Pagham Parish Council considered the following applications at a meeting of its Planning Committee held on 22nd November 2022:

P/153/22/RES Approval of reserved matters (appearance, layout, landscaping and scale) following outline planning permission P/140/16/OUT for the erection of 375no dwellings, together with public open space, play space, drainage, parking and associated infrastructure, landscape, ancillary and site preparation works, with access off Pagham Road. This site may affect a Public Right of Way. Amendments to layout. RESOLVED: To OBJECT to the application. A copy of the reasons for objection are attached.

P/153/22/RES – Approval of reserved matters (appearance, layout, landscaping and scale) following outline planning permission P/140/16/OUT for the erection of 375 no dwellings, together with public open space, play space, drainage, parking and associated infrastructure, landscape, ancillary and site preparation works, with access off Pagham Road. This site may affect a Public Right of Way.

In addition to previous comments submitted in connection with this application, Pagham Parish Council continues to OBJECT to the proposals for the following reasons:

LEAP (Local Equipped Area of Play) - Design Approach

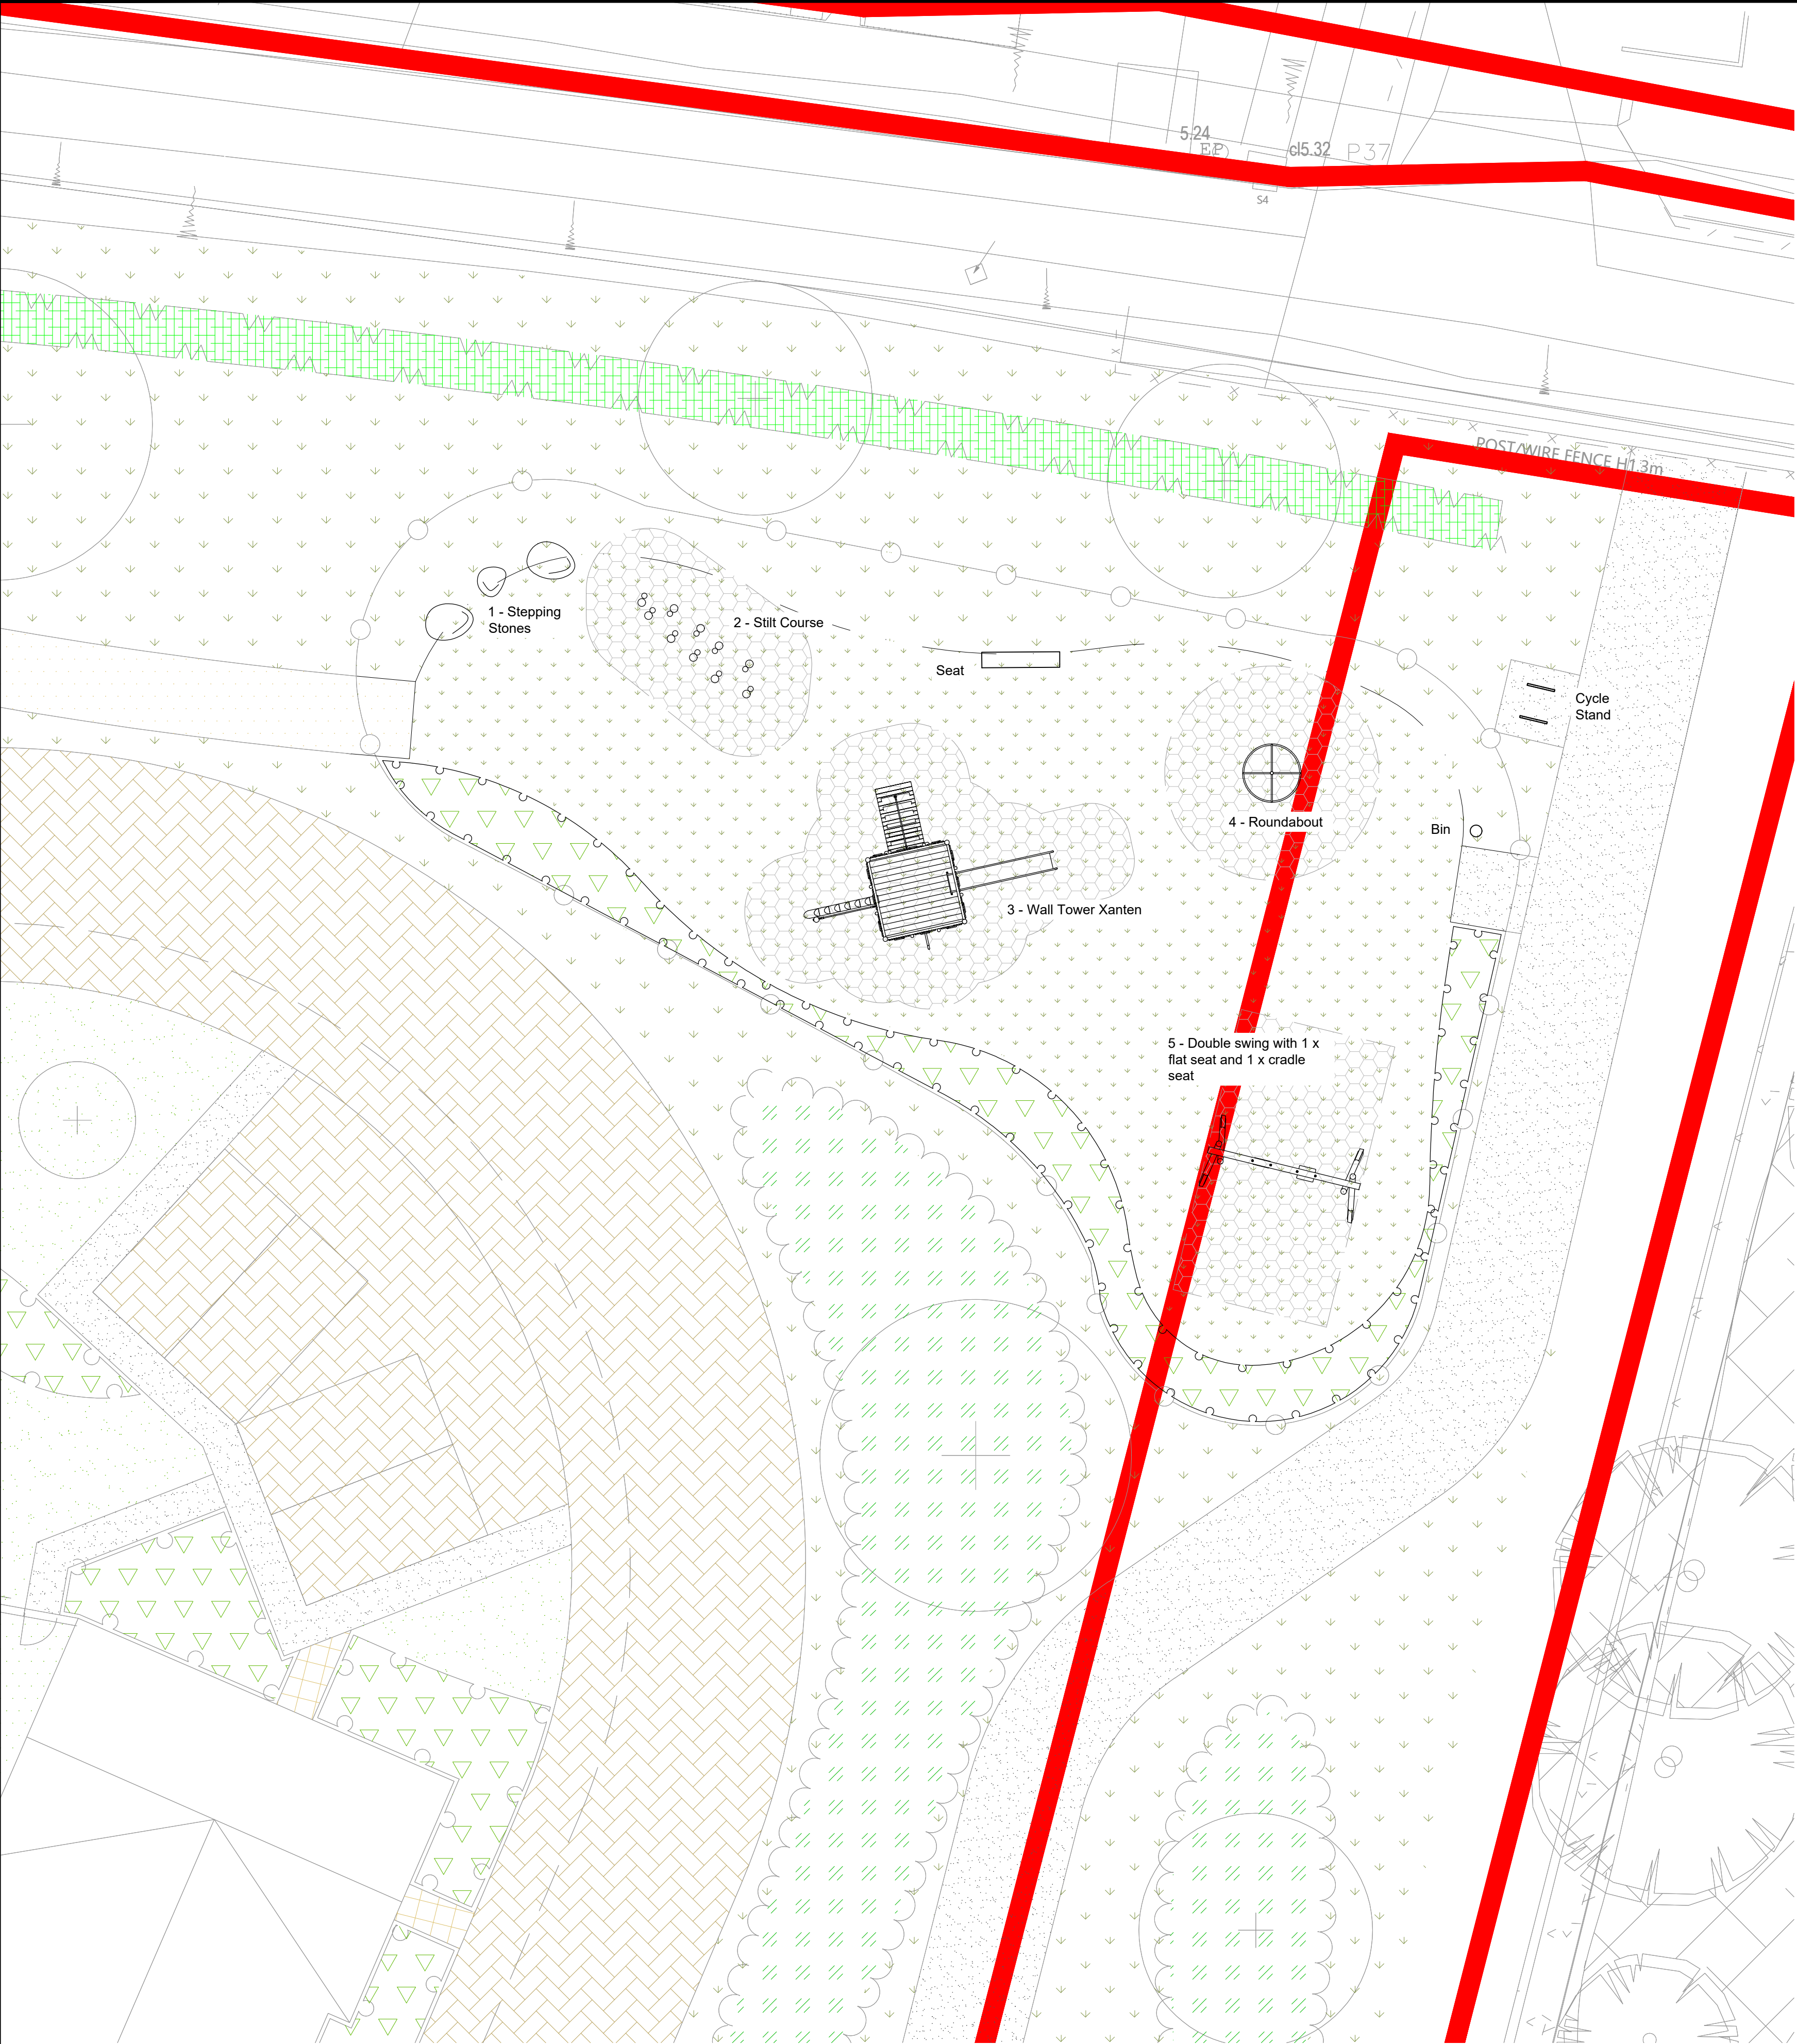
The play equipment provided at the various LEAP and ELAP sites lacks imagination. It would be helpful to know what the proposed heights of the various mounds proposed would be – recent experience with the mound at Summer Fields shows it is important to agree the details up front, to ensure there are no “blind spots” which might encourage antisocial behaviour.
